## PLAN EXAMINATION CONDITIONAL APPROVAL

**PROJECT/SITE DESCRIPTION:**  
Maine Medical – Visitor’s Garage Extension

**PROJECT ADDRESS:**  
22 Bramhall St – Portland, Maine

Review Type:	All Trades
Plans Date:	3/30/18
# of Sheets:	96
Project Area (sq. ft.):	82,201

Drawing file: 01 General / G02-01 - CODE COMPLIANCE ELEVATIONS.pdf

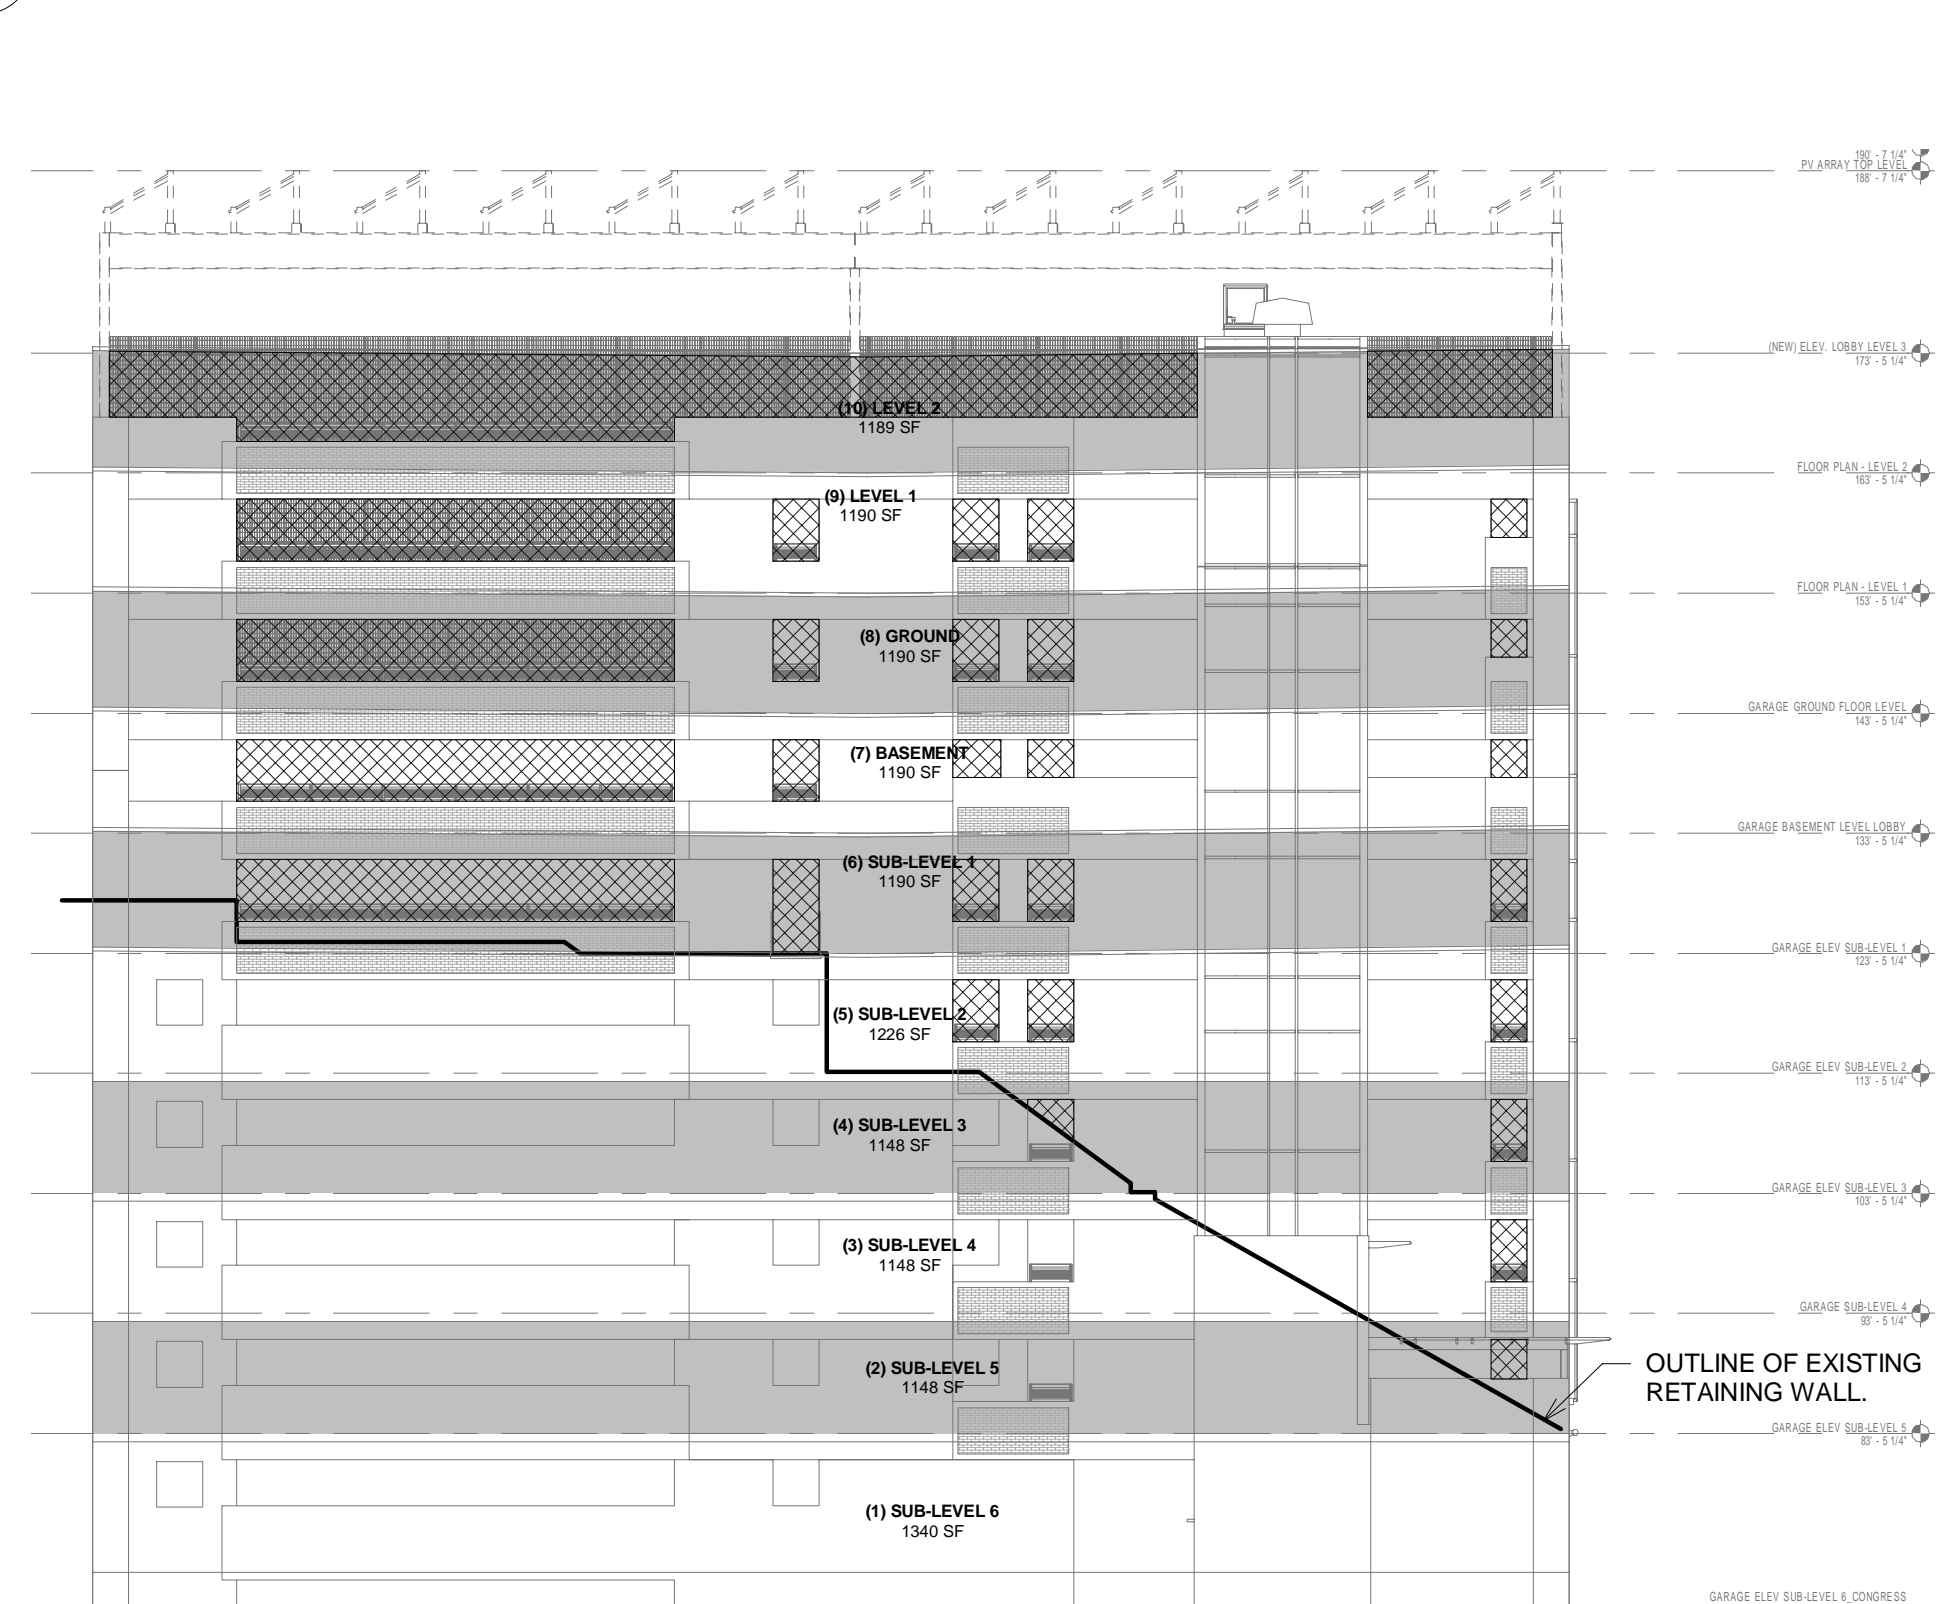
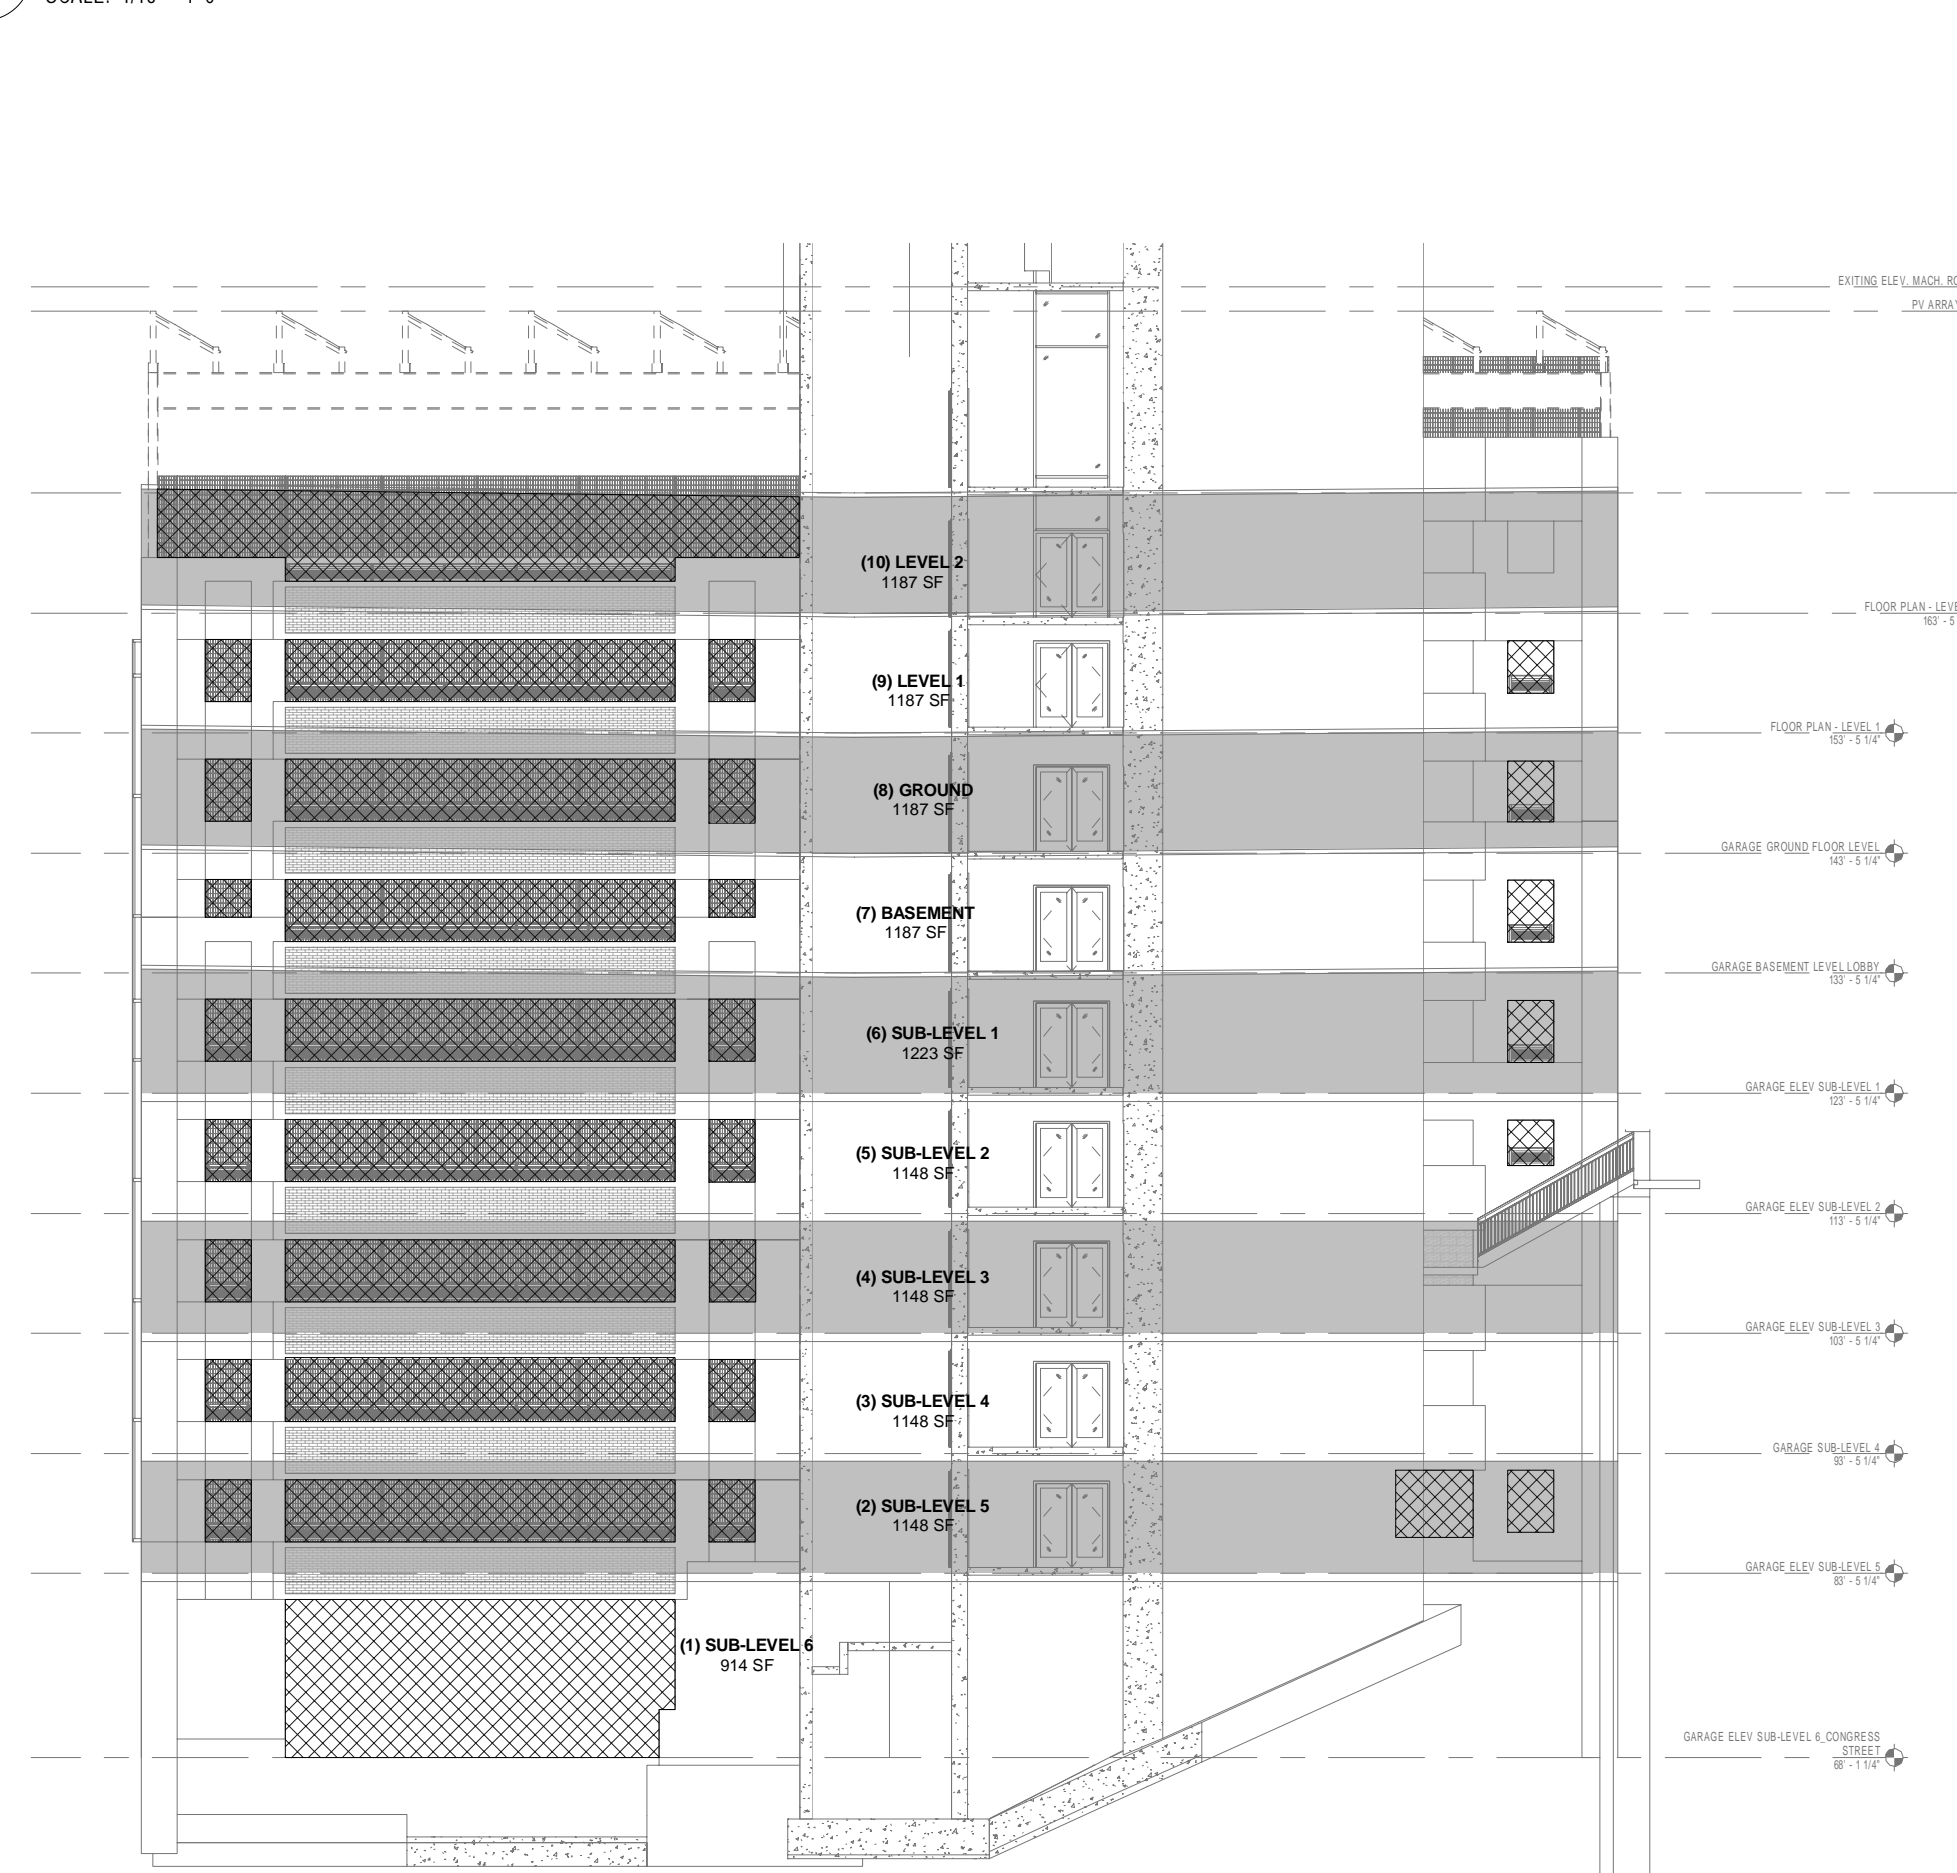
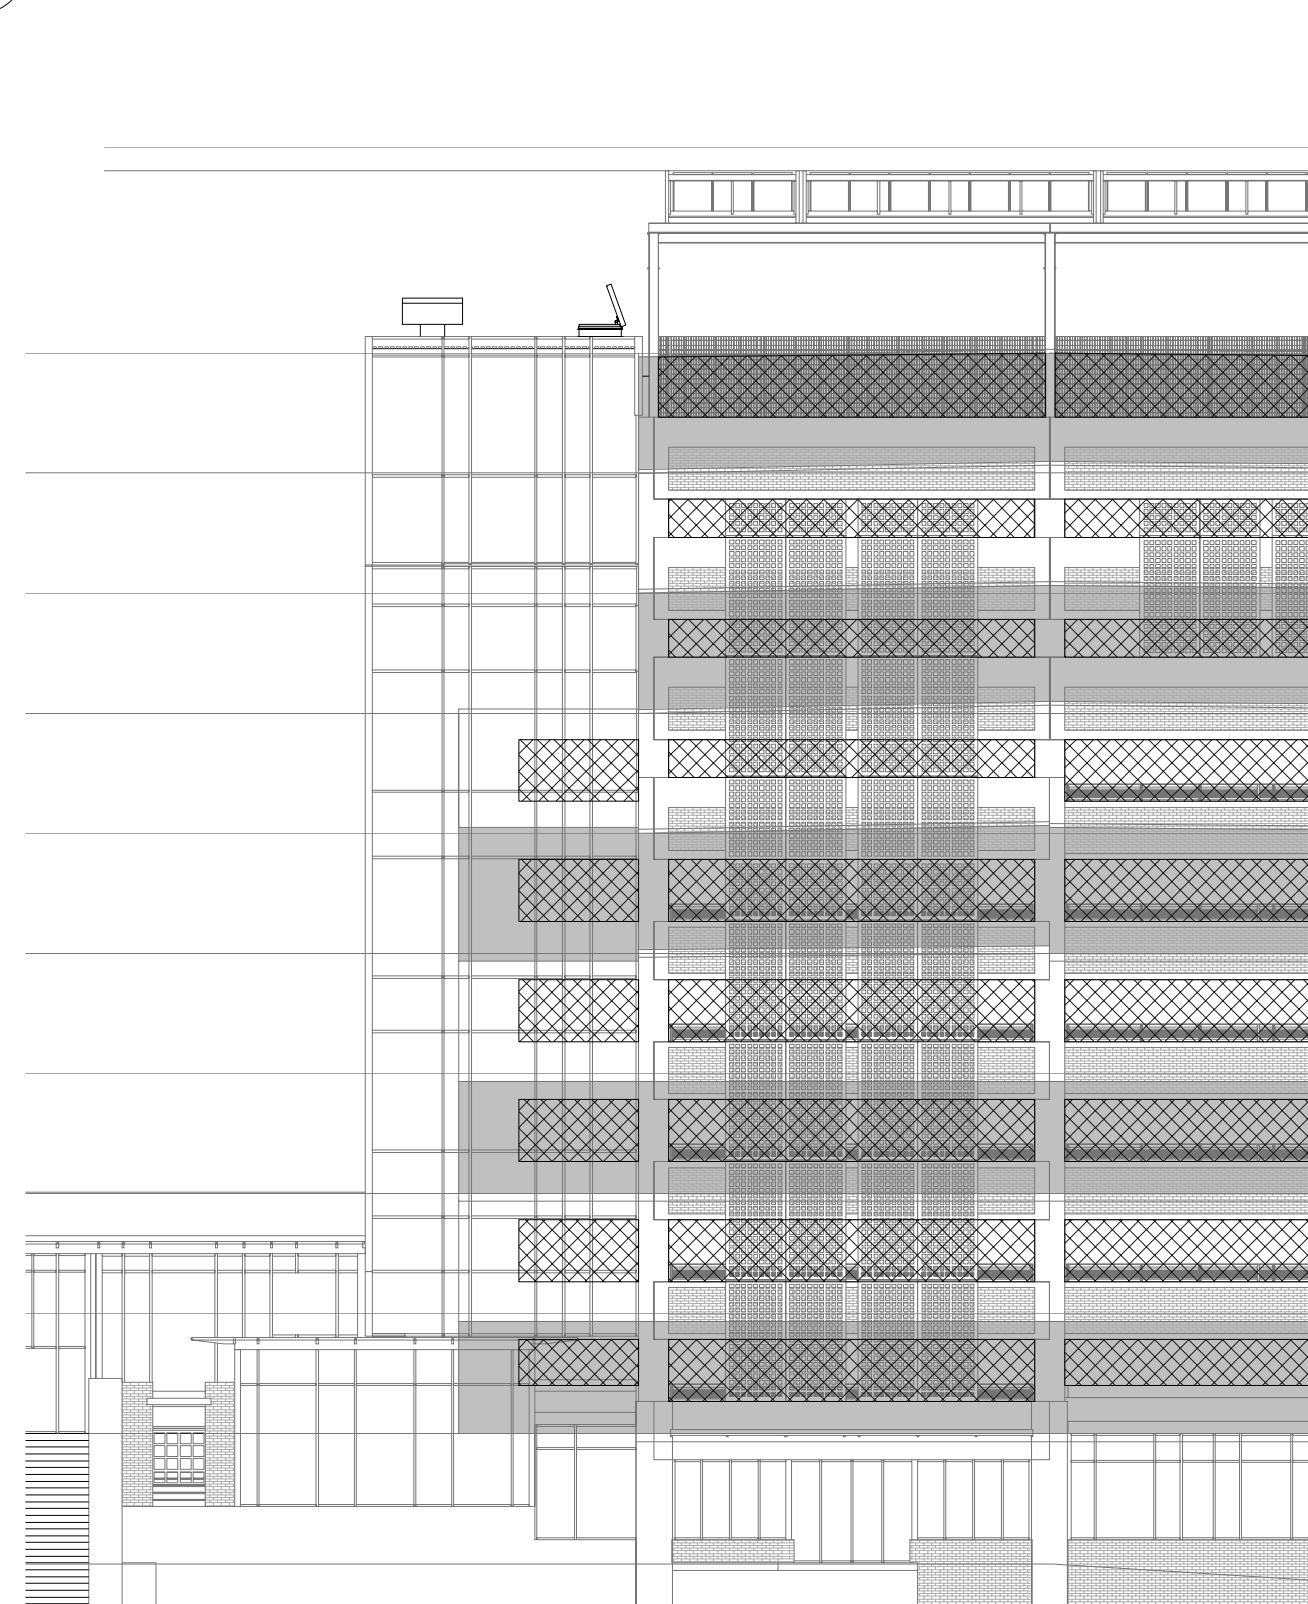
Plan Review Comments are based upon updated G02-01 Code Compliance Elevations sheets provided during review 3/27/18 demonstrating ventilation requirements meeting code requirements to allow for structure to be considered as an "Open Parking Structure".

The review of the above referenced project is for an open parking structure as clarified in revised G02-01. The plans submitted were architectural only. Shop drawings and calculations were not included in the submittal. They will be considered a differed submittal.

The review of the above referenced project is for an open parking structure as clarified in revised G02-01. NFPA 1, NFPA 101, NFPA 88A are the referenced applicable standards.
